From: Claire Rodway
Sent: 06 September 2010 10:50
To: Planning.Responses
Subject: FW: Planning Consultation. Ref: LU/229/10/

Outline application for redevelopment of site: Demolition of 2 bungalows, workshop, glasshouses and incidental development with erection of 91 dwellings with improved means of access onto Worthing Road (including closure of existing 2 accesses) with all other matters reserved.

Windroos Nursery, Worthing Road, Littlehampton. Ref: LU/229/10/

31. Landscape structure plan

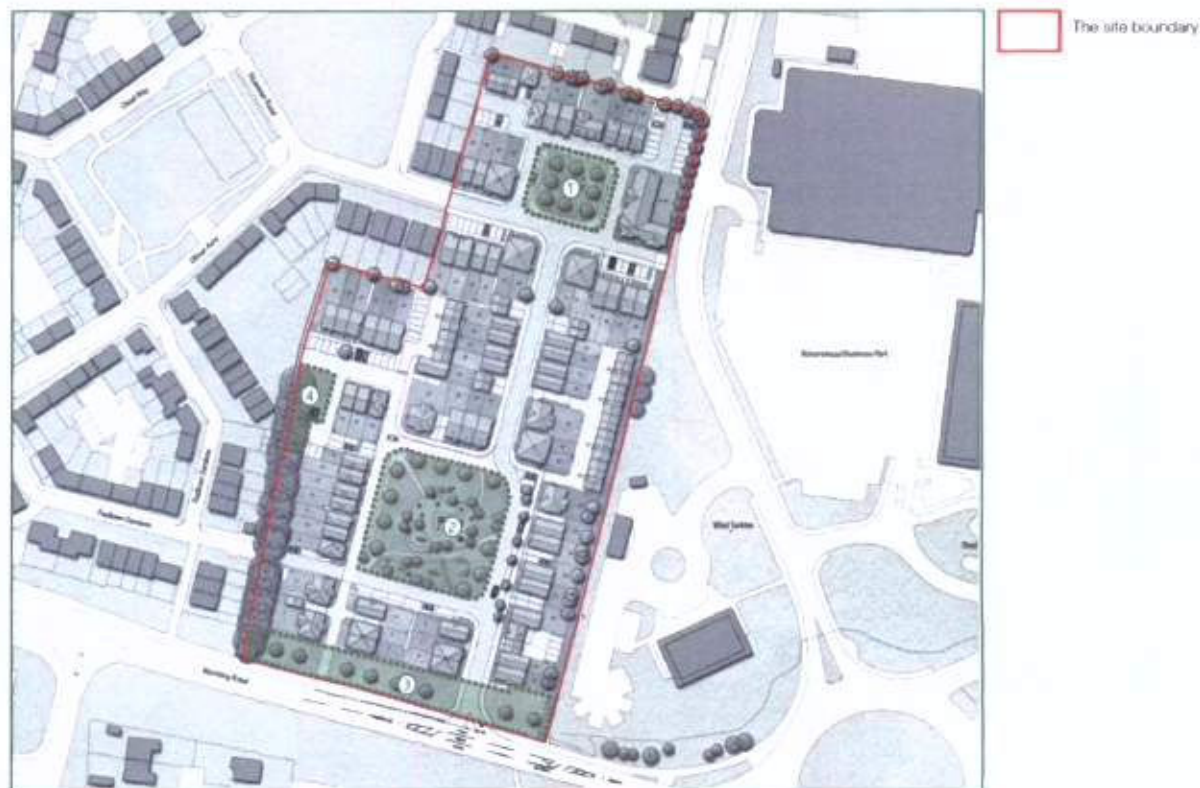
Ideally all the open space should be provided on site - i.e. the 0.48 ha calculated - I realise this can be calculated in different ways - they have used the WSCC calculator - I have used the census 2001. In accordance with our SPG I do not consider that part of their allocation of POS as appropriate - the area adjacent to the highway at the southern portion of the site which could be described as highway verge.

The LAP and LEAP proposed for the development is sufficient. The definition of what should be provided is contained within the Fields in Trust publication Planning and Design for Outdoor Sport and Play 2008 ('the new six acre standard'). I can provide a copy photocopy of relevant extracts if necessary.
